SCOPING OPINION:

Proposed Hedgehog Grove Solar Farm

Case Reference: EN0110021

02 June 2025

Figure 1.2
Developable Areas
Scoping Report
Hedgehog Grove Solar Farm

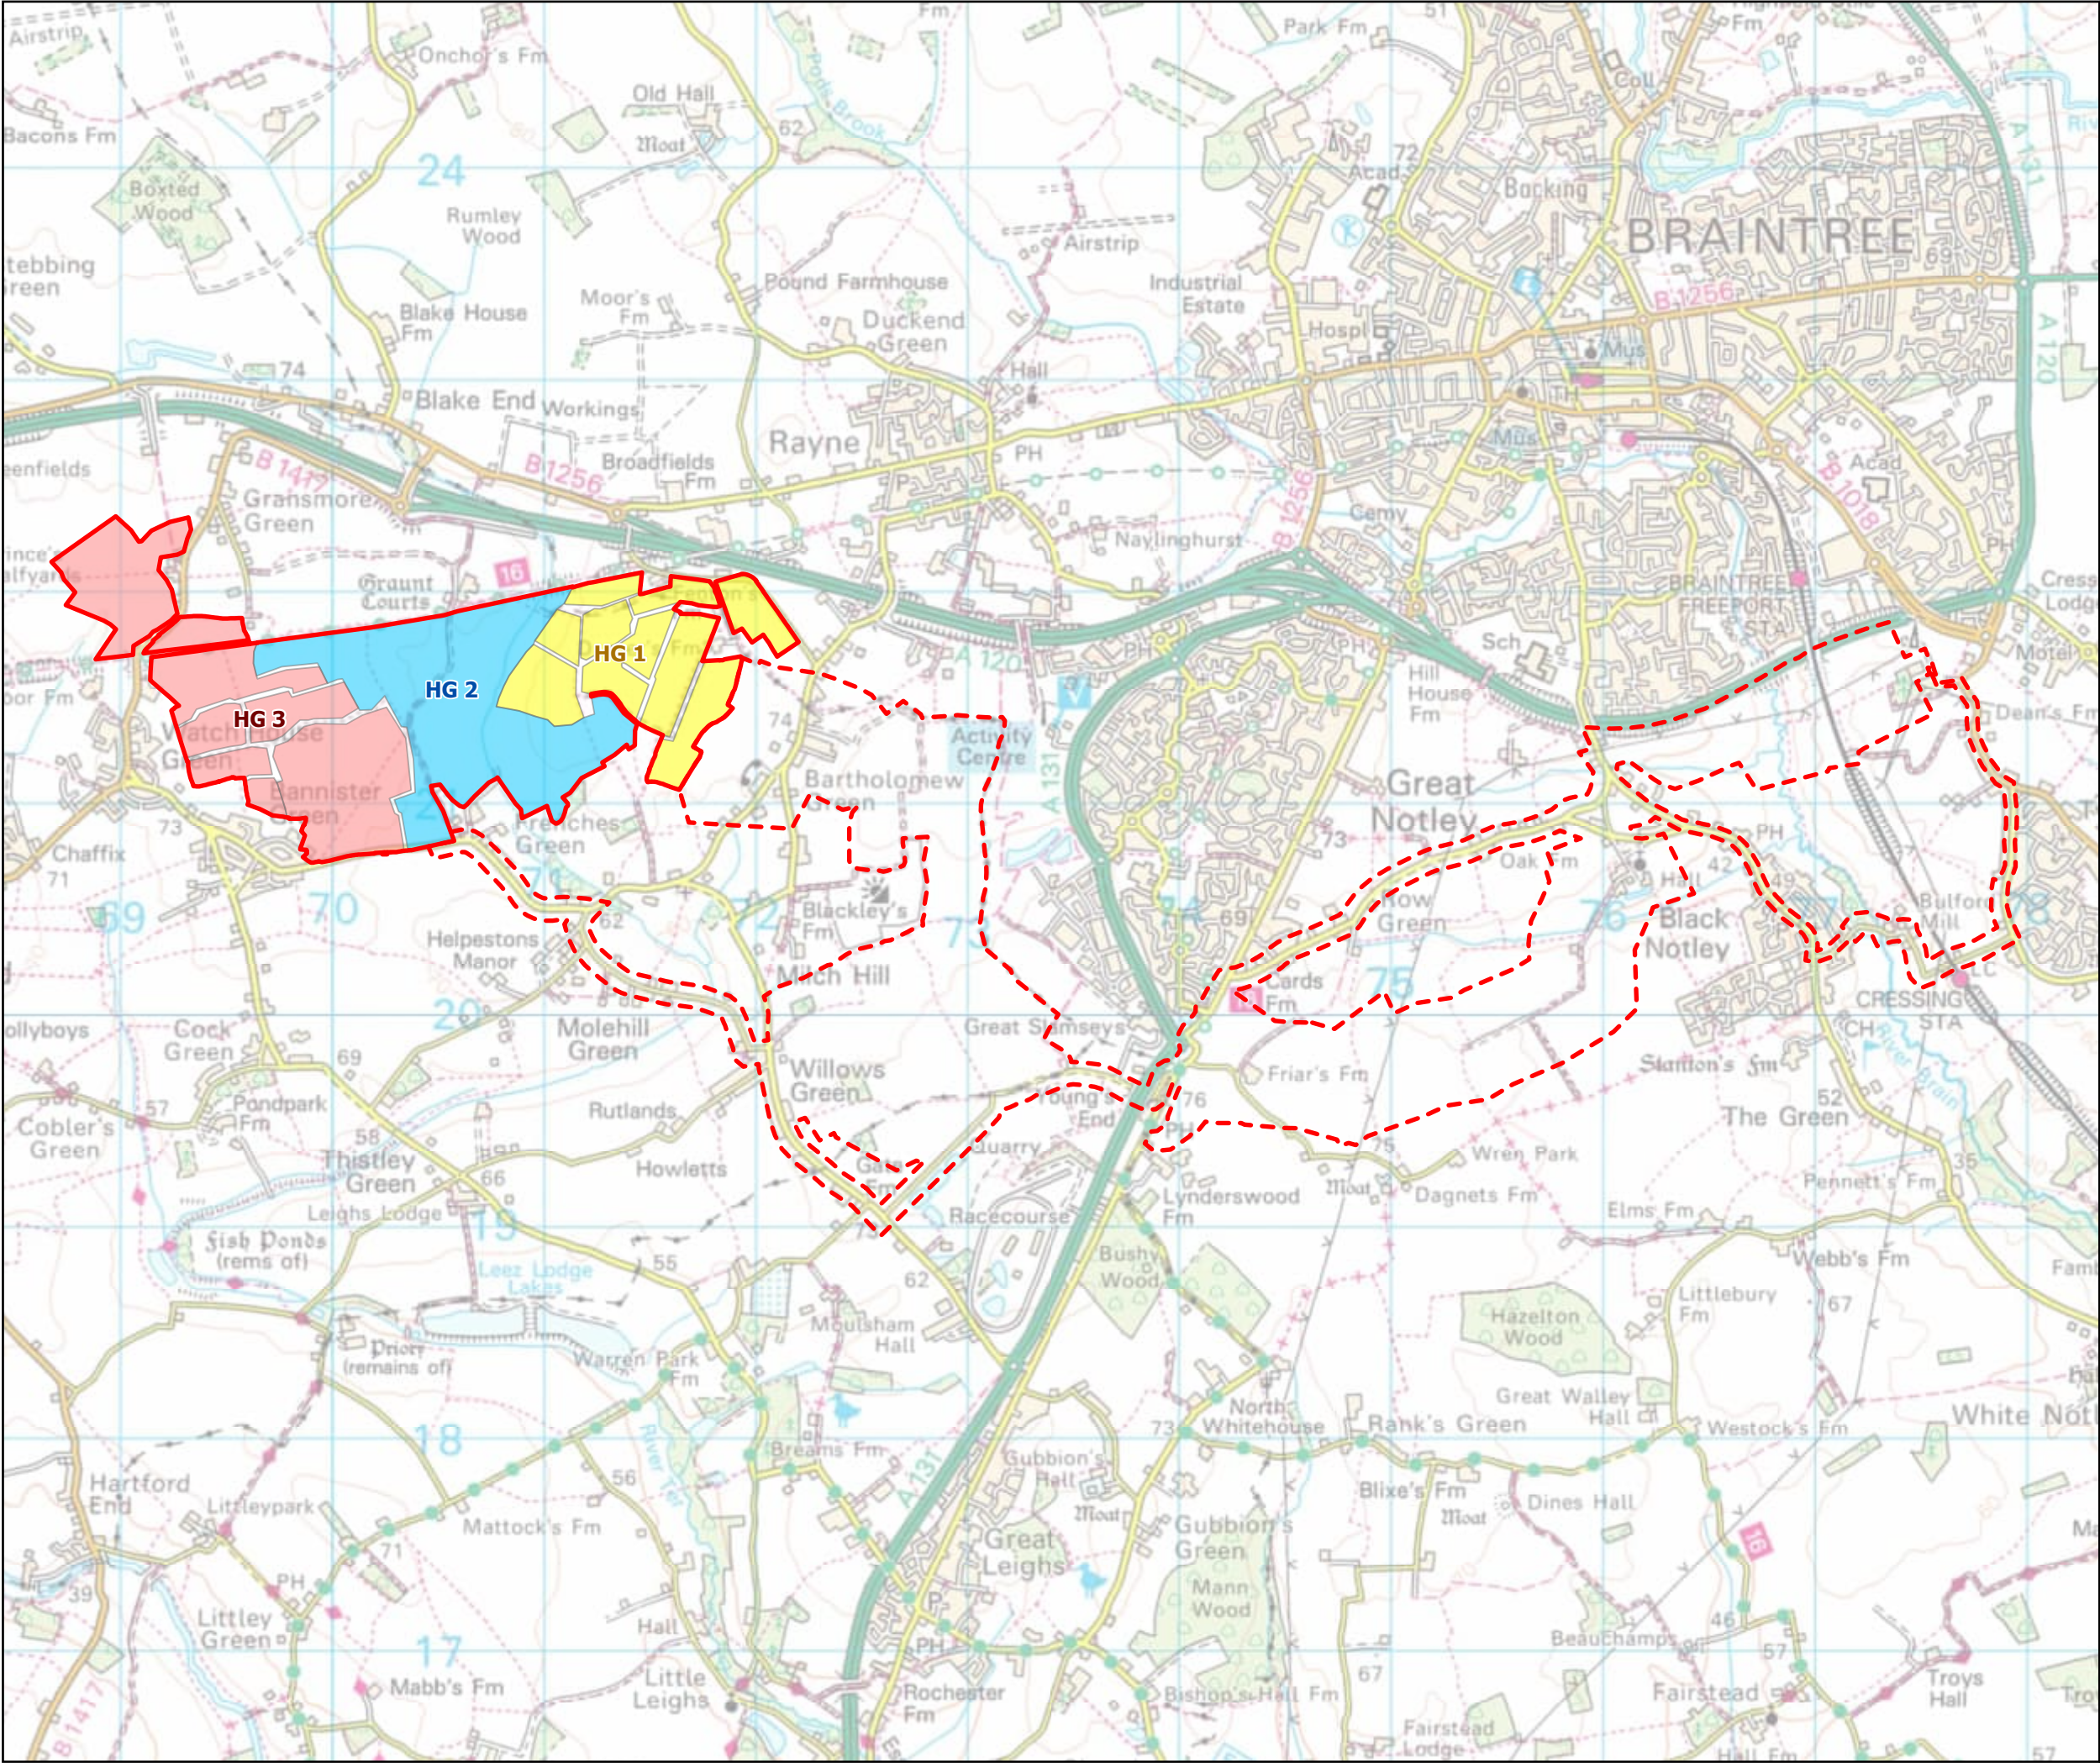
21.2	Paragraph 1.1.8; figure 1.3	Additional land for cable connections	The Scoping Report states that figure 1.3 illustrates the maximum area of land required for the proposed development at this point of the design. However, figure 1.3 shows that there are parcels of 'developable solar area' within the order limits that are not connected to the main site boundary or connection corridor options. For example, the small parcels of land located in the north west of the site are separate from the main site boundary. The ES should clearly define the extent of the proposed development and identify any likely significant effects of the entire proposed development, including any cable connections between parcels of land within the DCO boundary.

Figure 7.1
Air Quality Study Area
Scoping Report
Hedgehog Grove Solar Farm

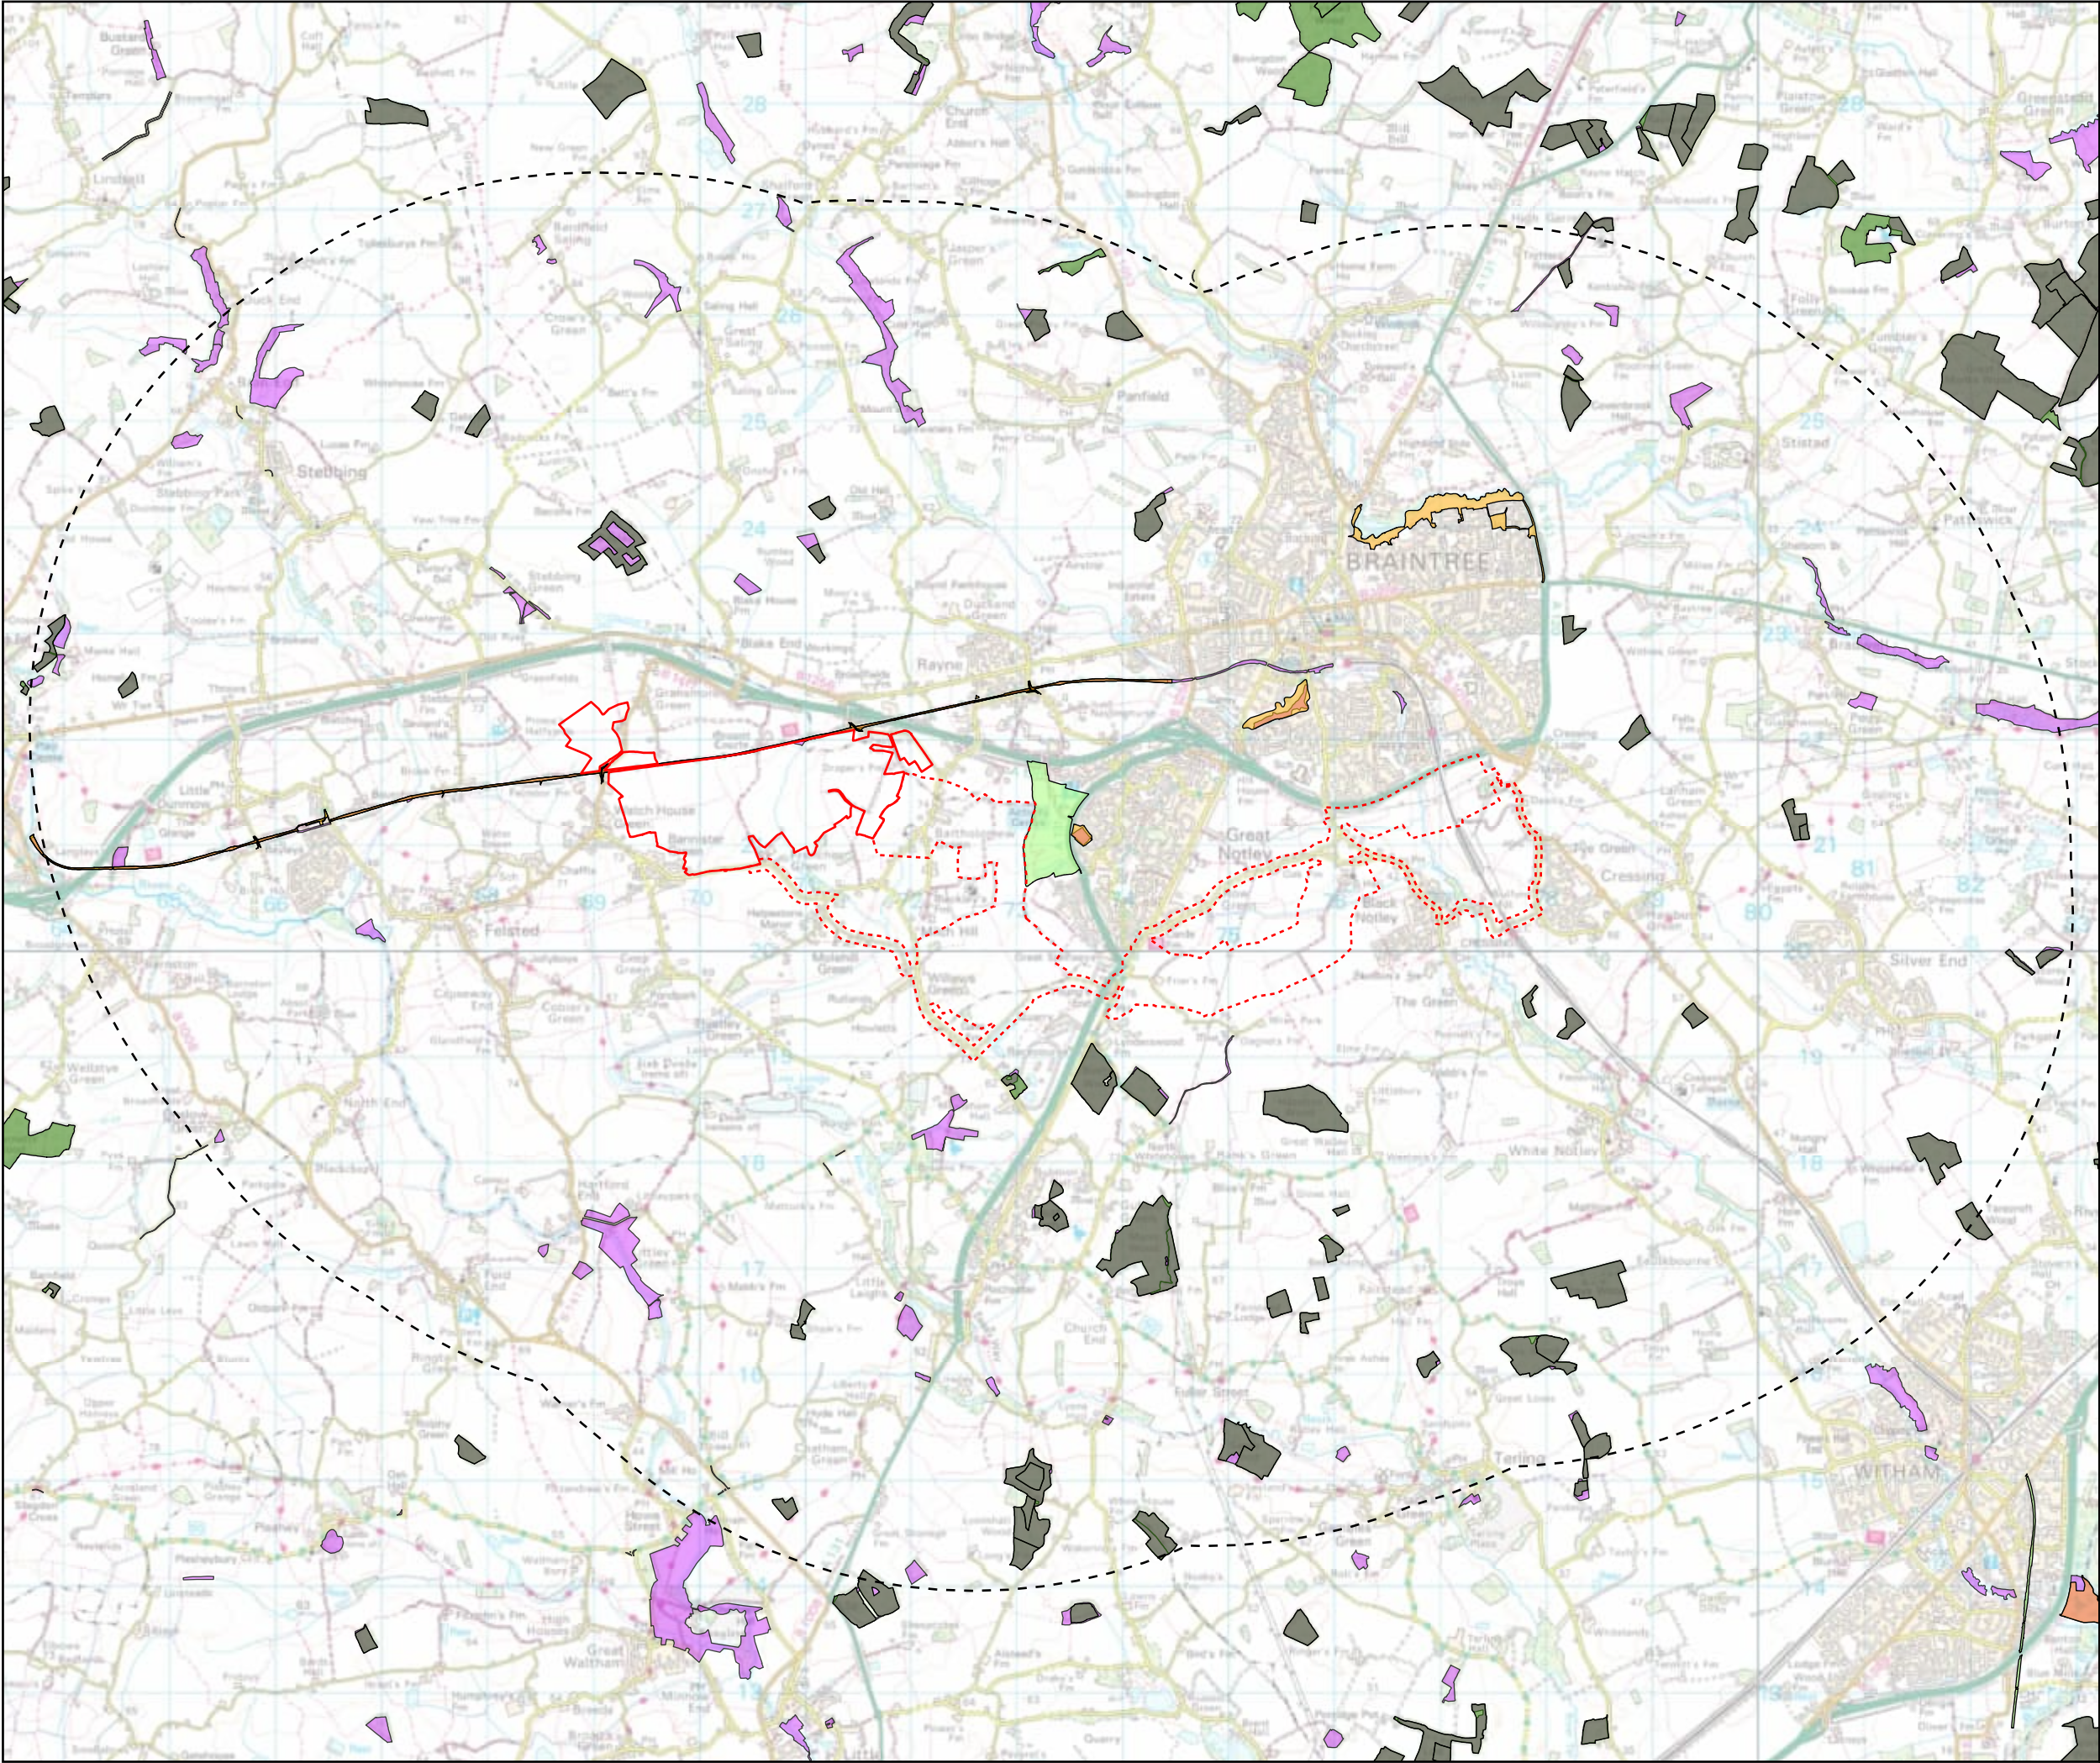
ID	Ref	Description	Inspectorate's comments
3.1.3	Paragraph 7.3.3; figure 7.1	Study area	The Scoping Report states that the study area for the proposed development will be based on activities within 250m of the site boundary, including solar PV areas and cable corridor options. The ES should include an explanation of the study areas used to identify potential significant air quality effects on human and ecological receptors with reference to relevant guidance. This should be supported by appropriate figures. The assessment methodology and selection of study areas should also be discussed and agreed with relevant consultation bodies.
